SOLACE APARTMENTS FILING NO. 1 - SAND CREEK CENTER TRIBUTARY

CHANNEL IMPROVEMENTS

EPC STORMWATER REVIEW COMMENTS
IN ORANGE BOXES WITH BLACK TEXT

**SAND CREEK-CENTER TRIBUTARY CHANNEL PROFILE (3)  
STA 6+00.00 TO 11+00.00**

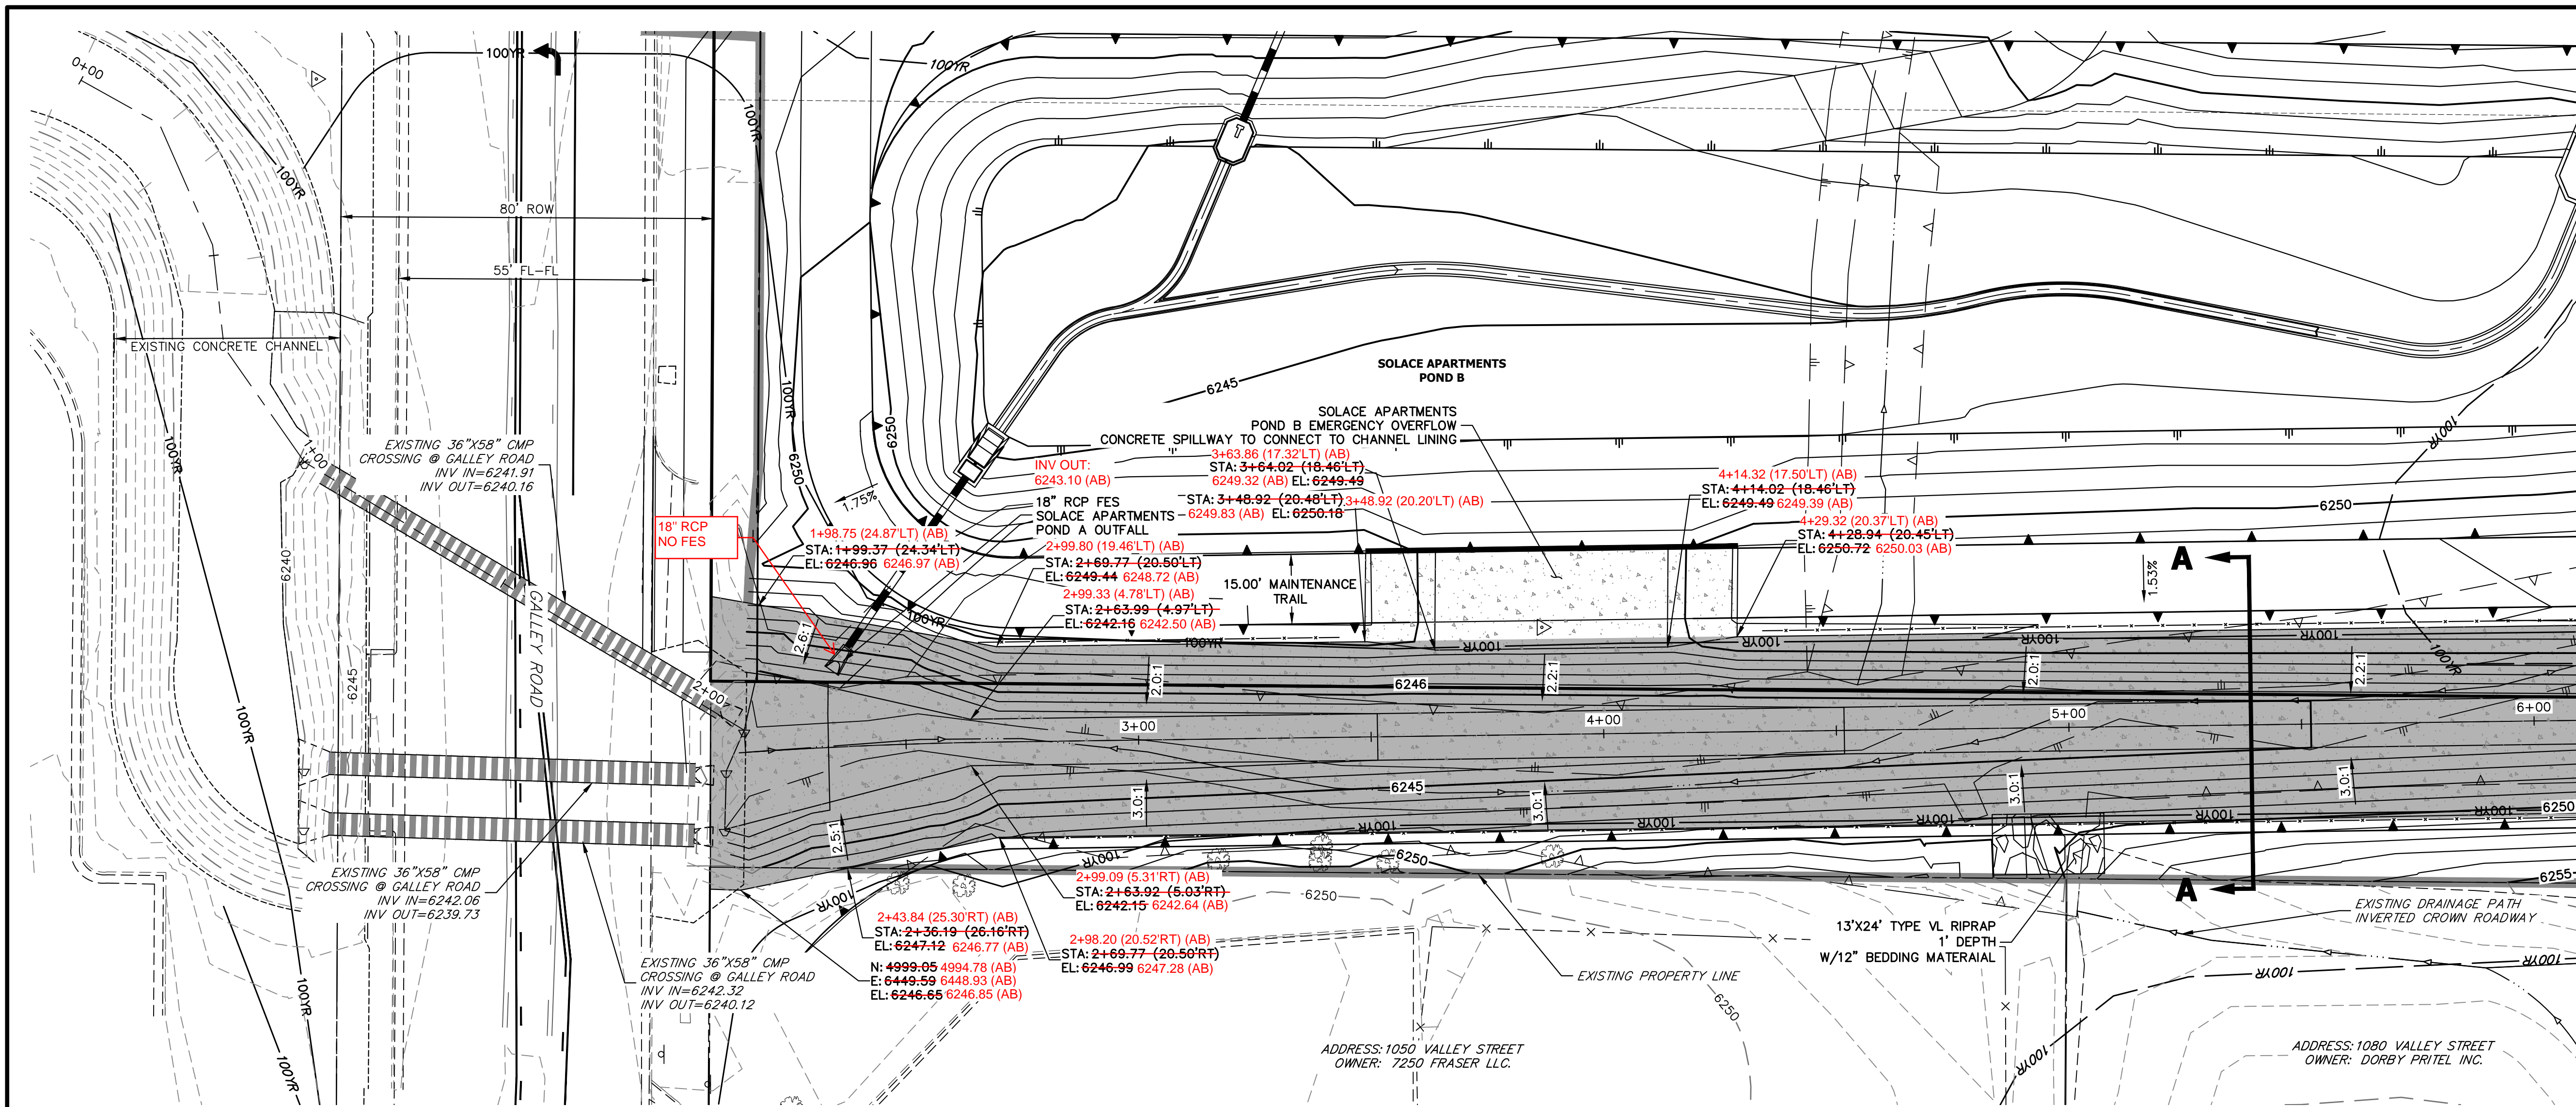
No FES was observed in the field. Acknowledge this deviation in the as-builts.

**DROP 1 PROFILE  
STA 12+60.00 TO 14+65.00**

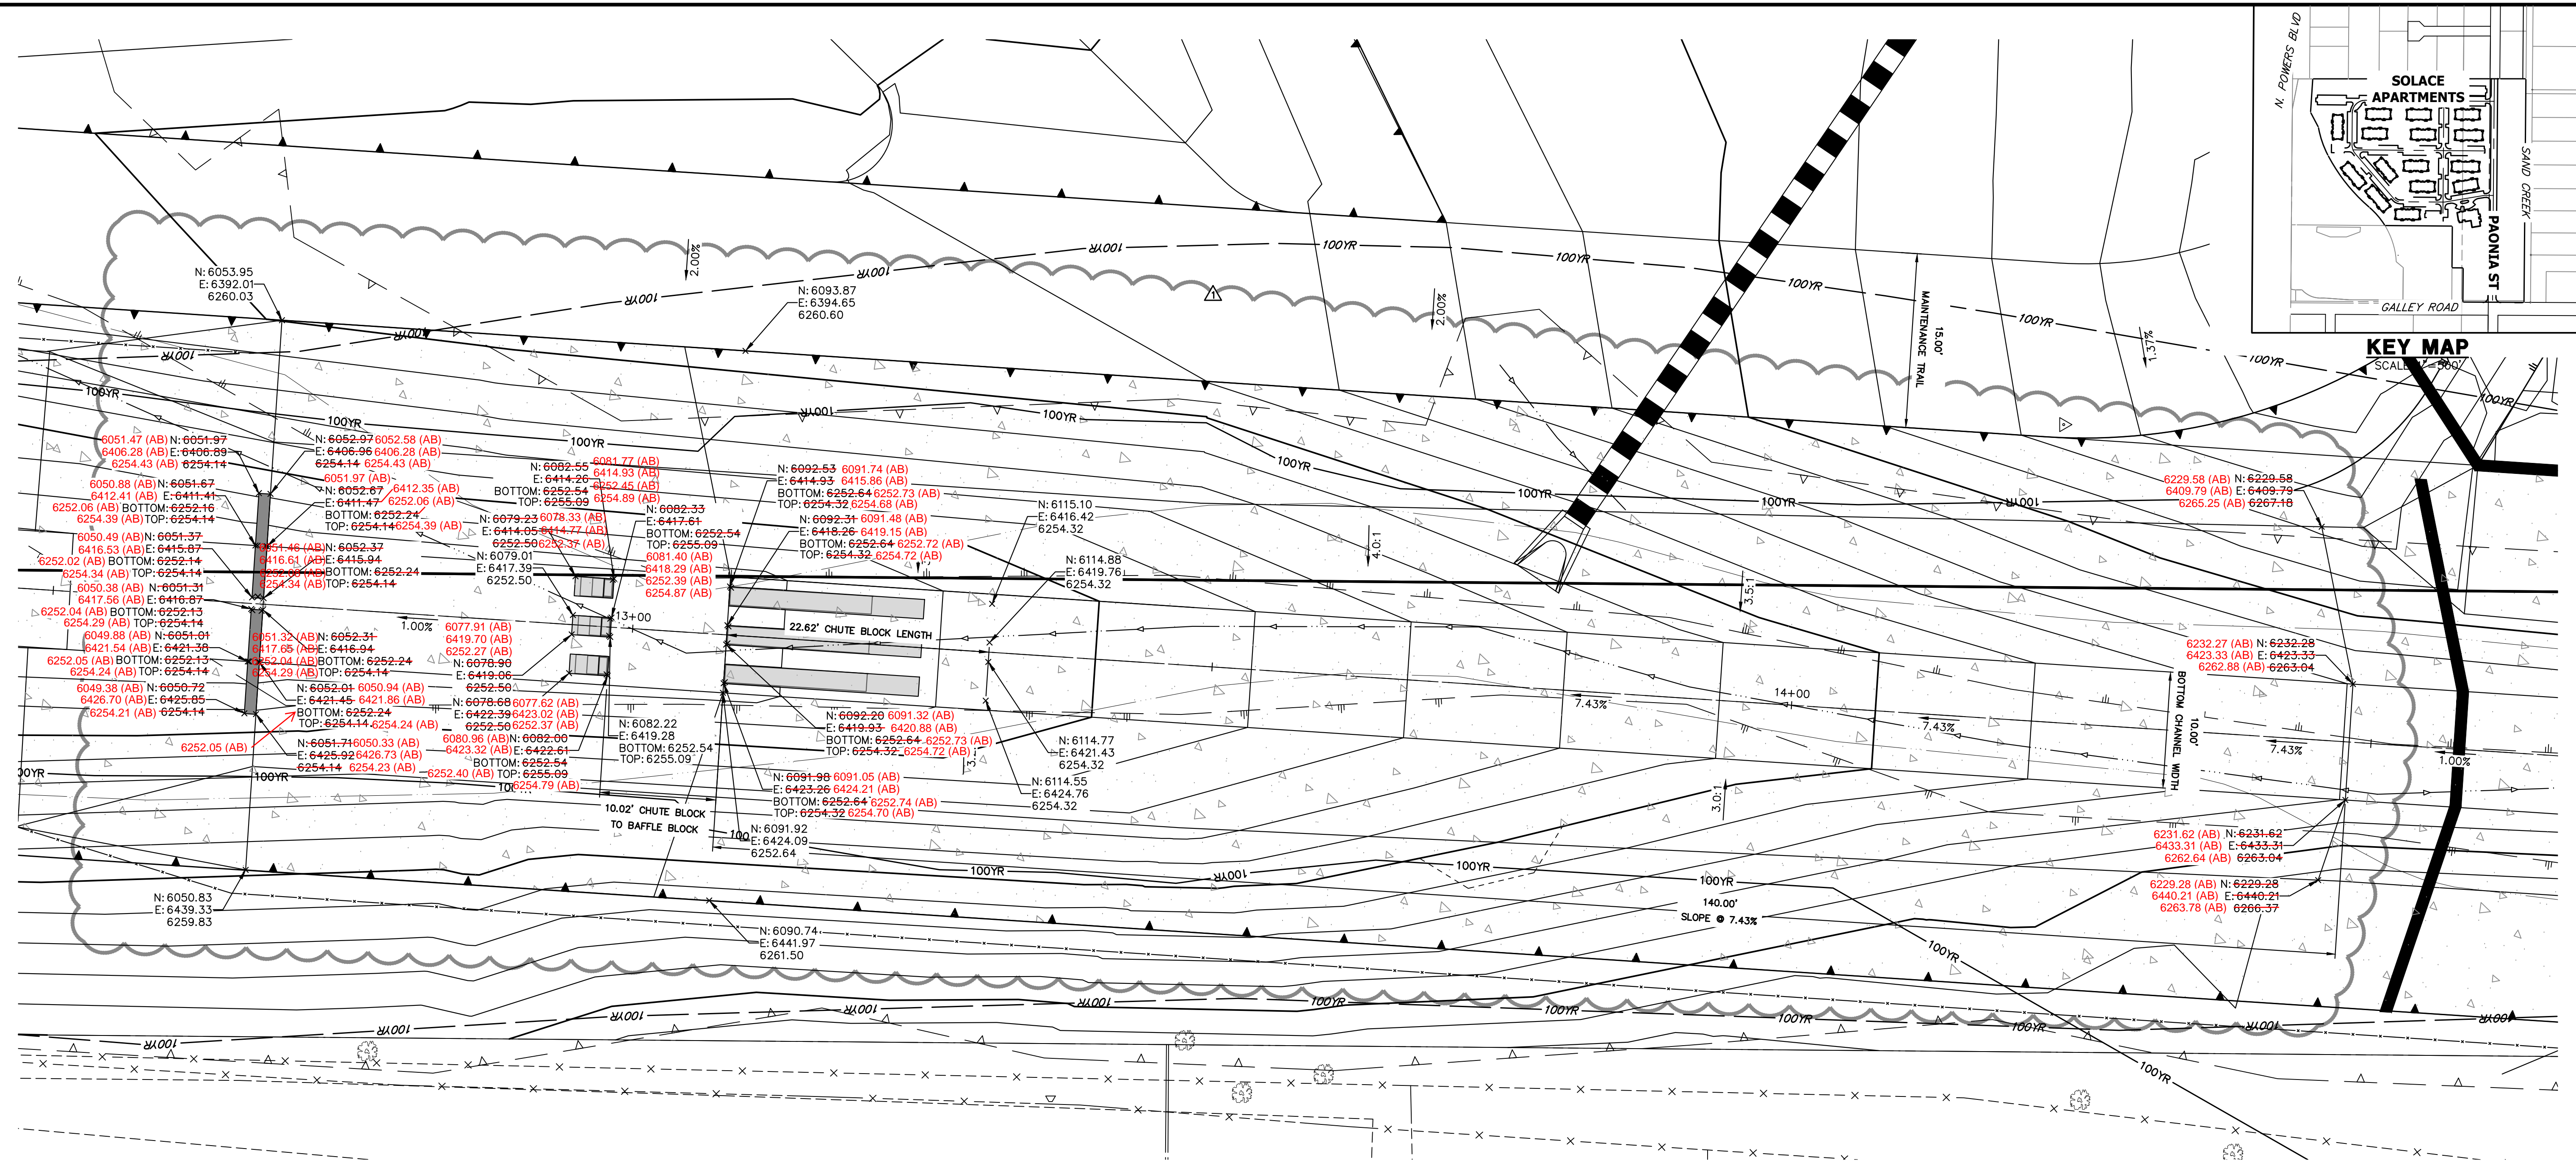
In the field the inspector measured 2', verify.
